**FIVE ESTUARIES OFFSHORE  
WIND FARM**

**SCHEDULE OF CHANGES TO THE DRAFT  
DEVELOPMENT CONSENT ORDER  
(TO REVISION E, DEADLINE 4)**

Application Reference	N/A
Application Document Number	N/A
Revision	N/A
APFP Regulation:	N/A
Date	December 2024

APFP Regulation: 5(2)(k)
 Sheet No: 11 of 20

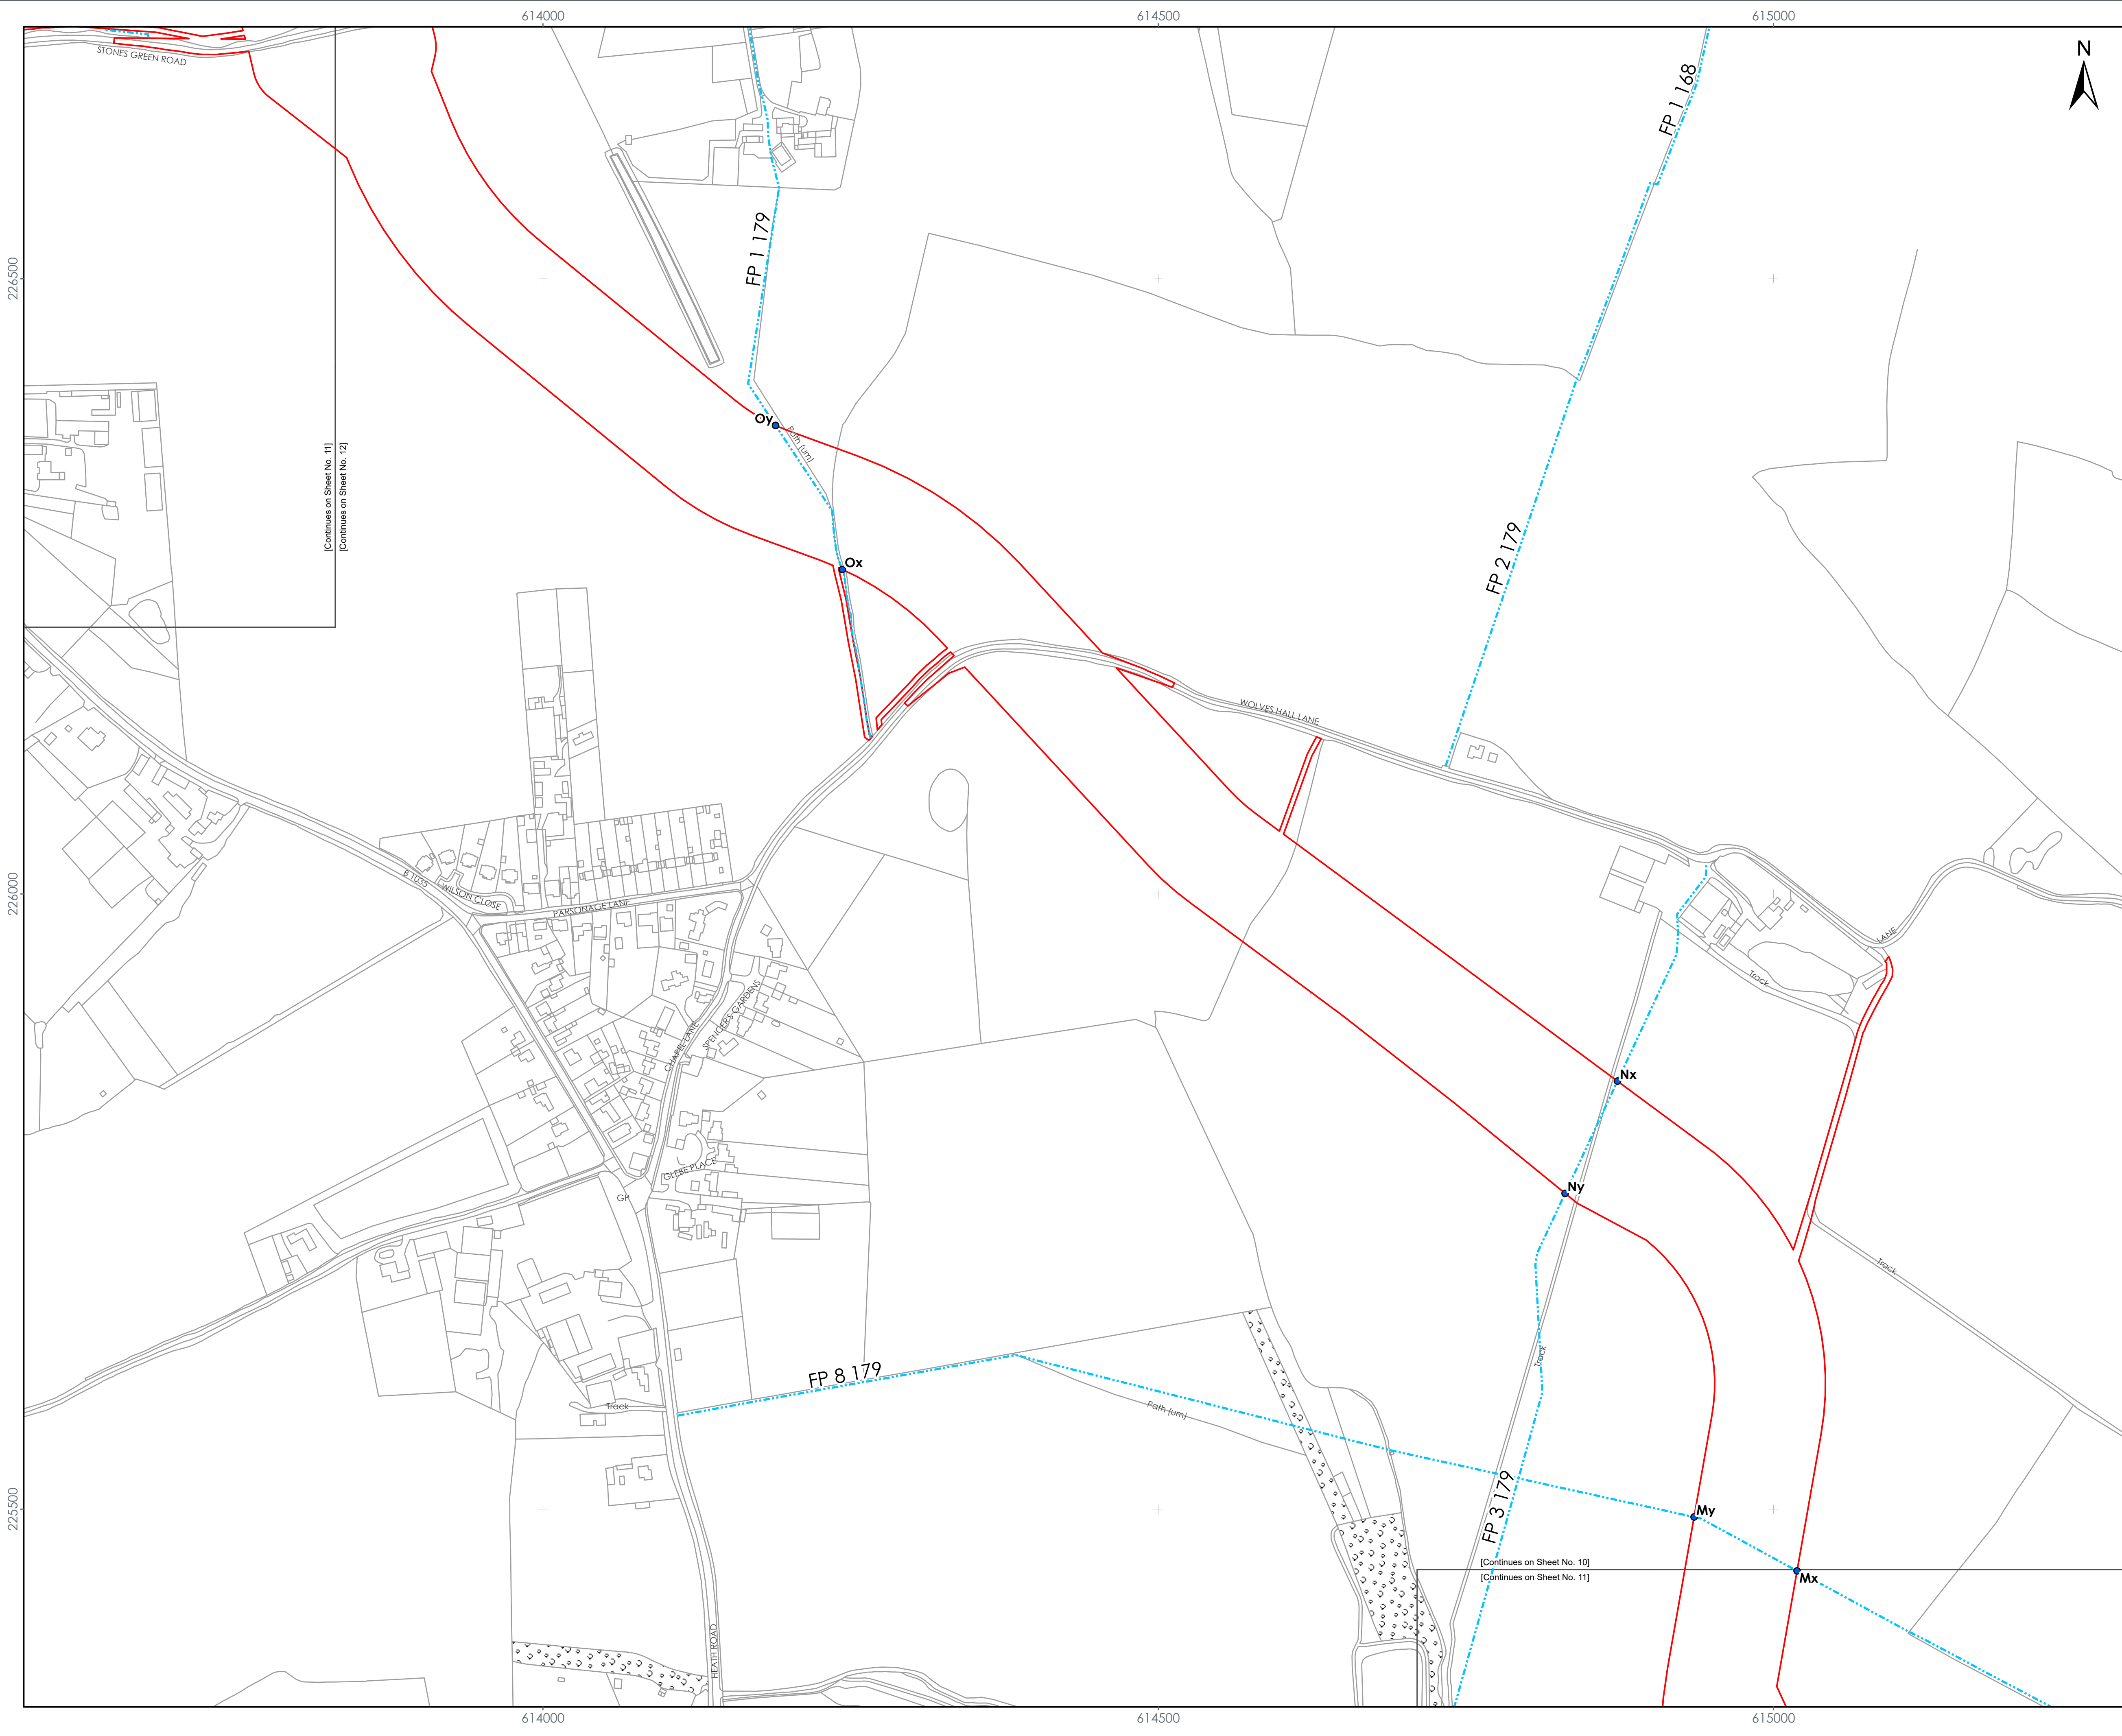
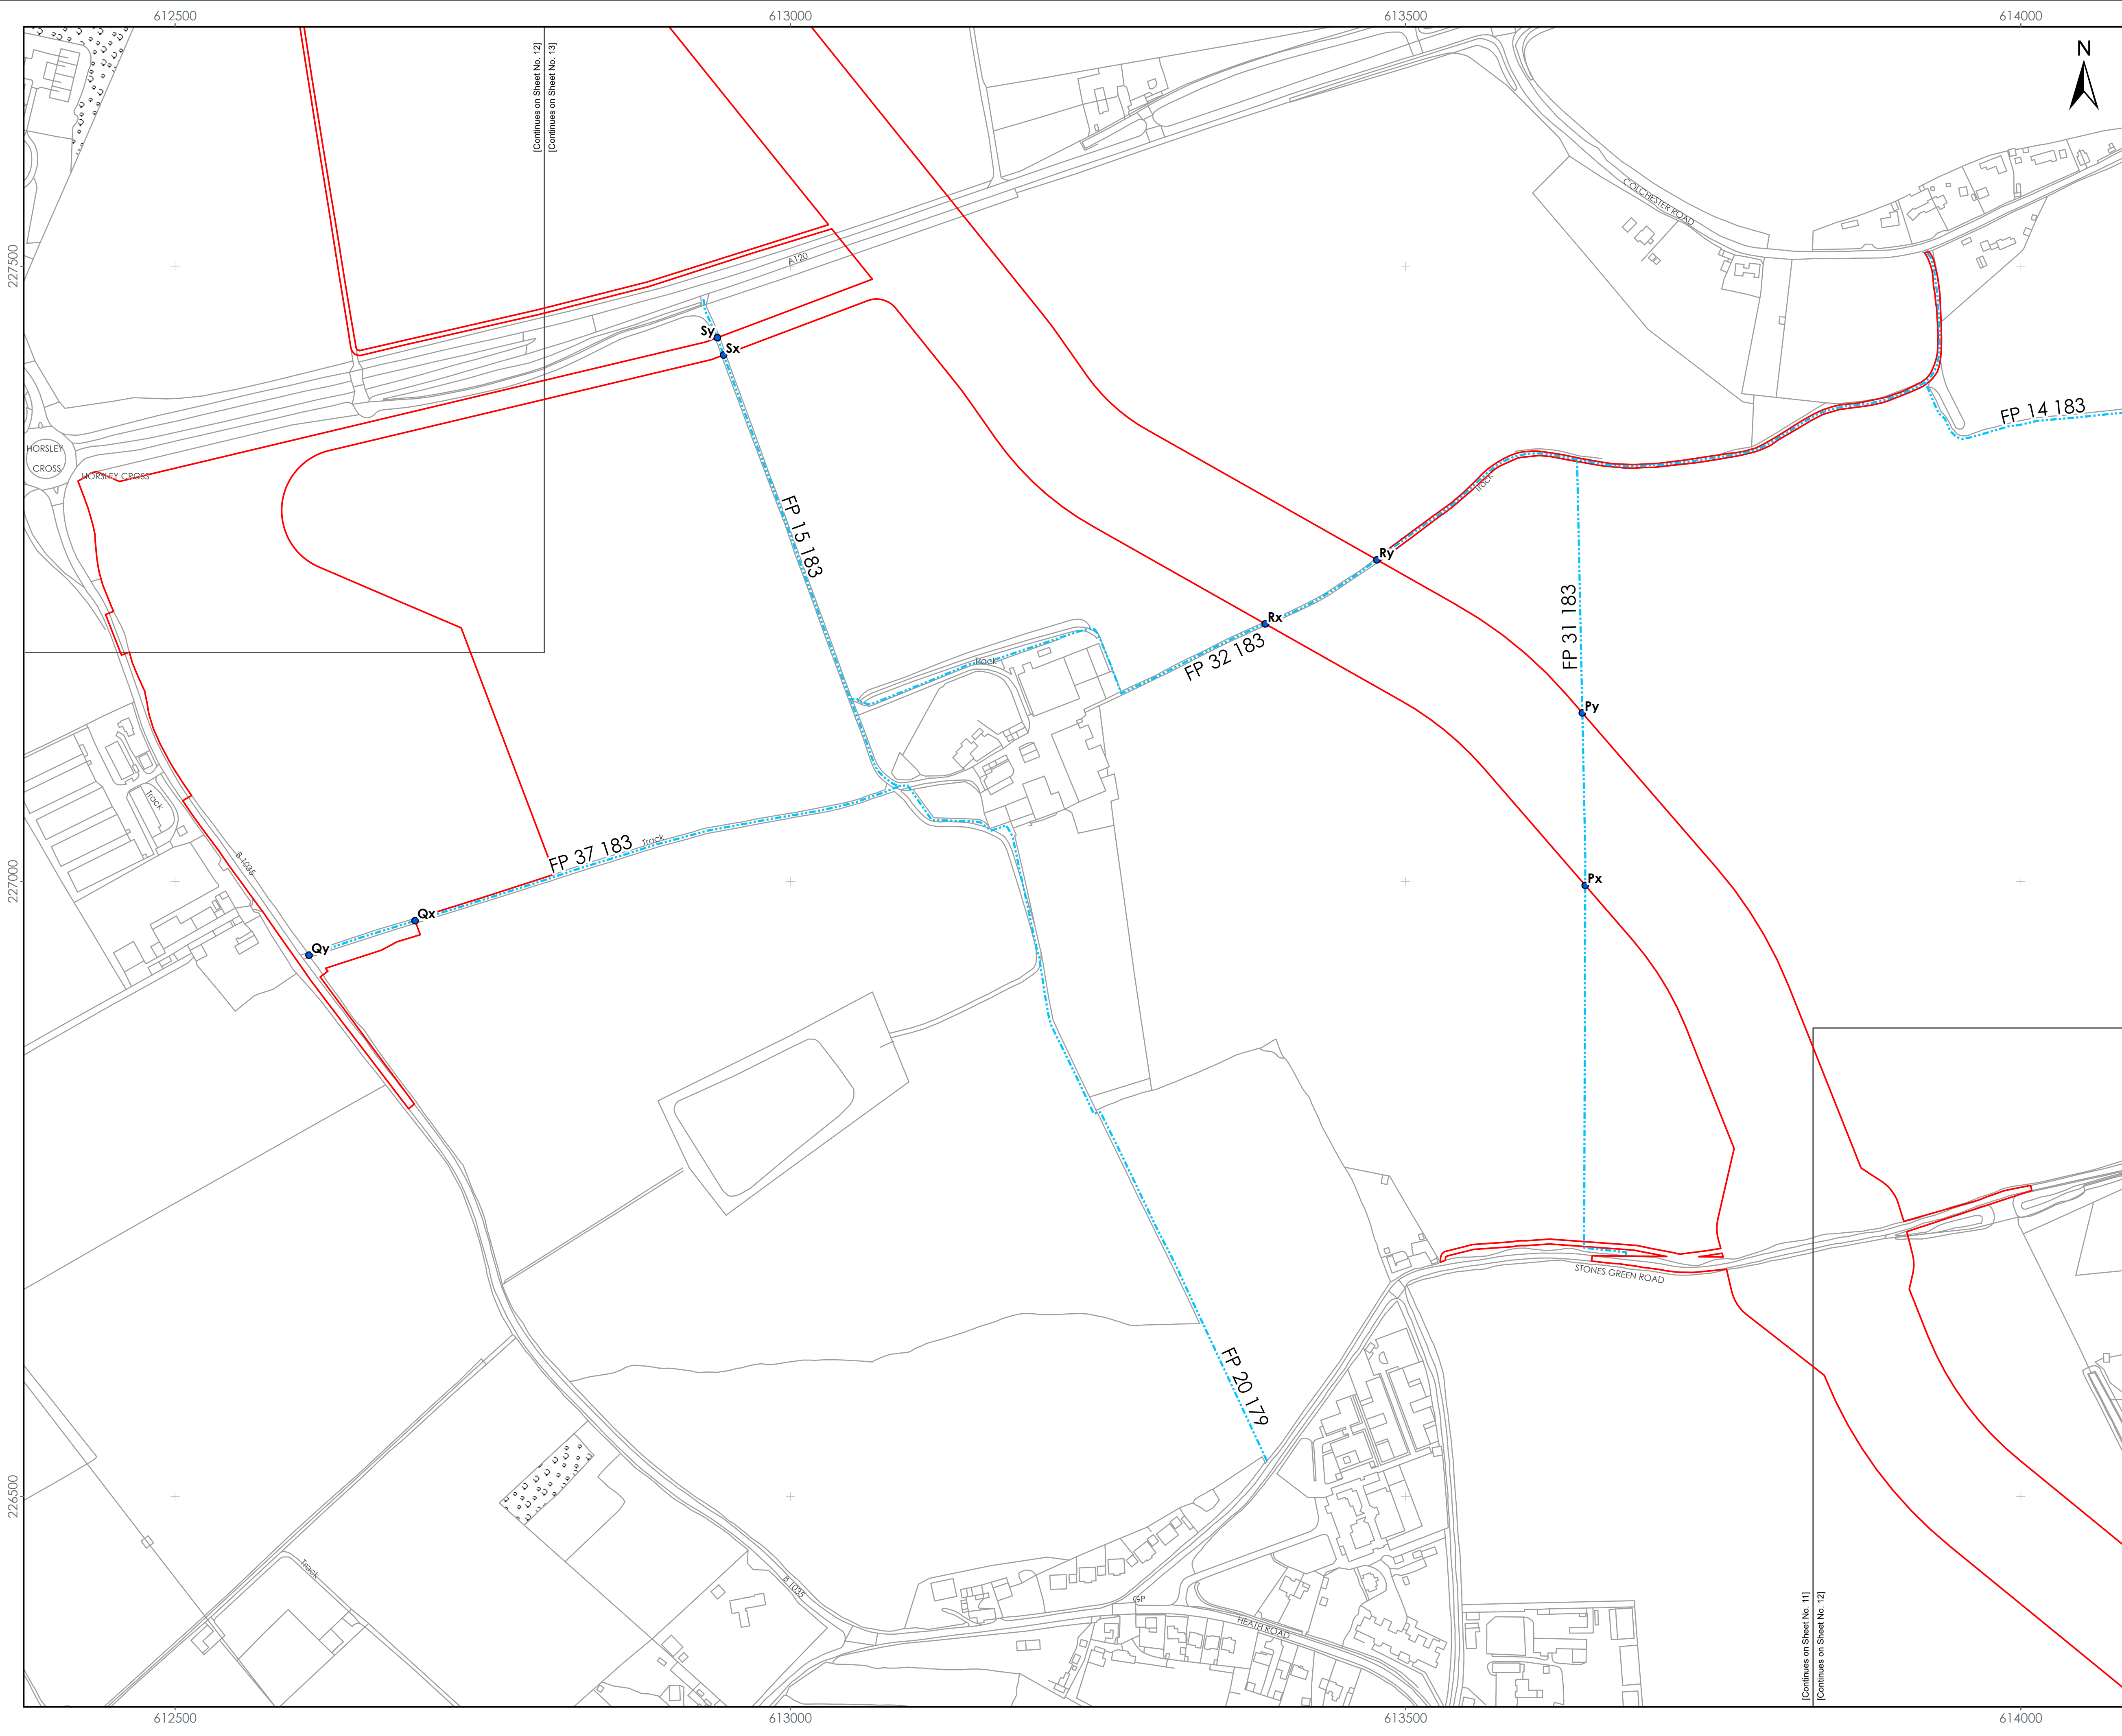
<table border="1"> <tr> <td>FP8 179</td> <td>Between points <a href="#">Mw to Mx</a> and <a href="#">My to Mz</a> as shown on sheets 10 and 11 of the temporary closure of public rights of way plan</td> </tr> </table>		FP8 179
FP8 179	Between points <a href="#">Mw to Mx</a> and <a href="#">My to Mz</a> as shown on sheets 10 and 11 of the temporary closure of public rights of way plan		
	Part 4, Speed limits	To add the additional speed limits forming part of the change request and to correct a typographic error	
	<table> <tr> <td><i>(1) Area</i></td> <td><i>(2) Road name, number</i></td> <td><i>(3) Speed Limit and length</i></td> </tr> </table>		<i>(1) Area</i>
<i>(1) Area</i>	<i>(2) Road name, number</i>	<i>(3) Speed Limit and length</i>
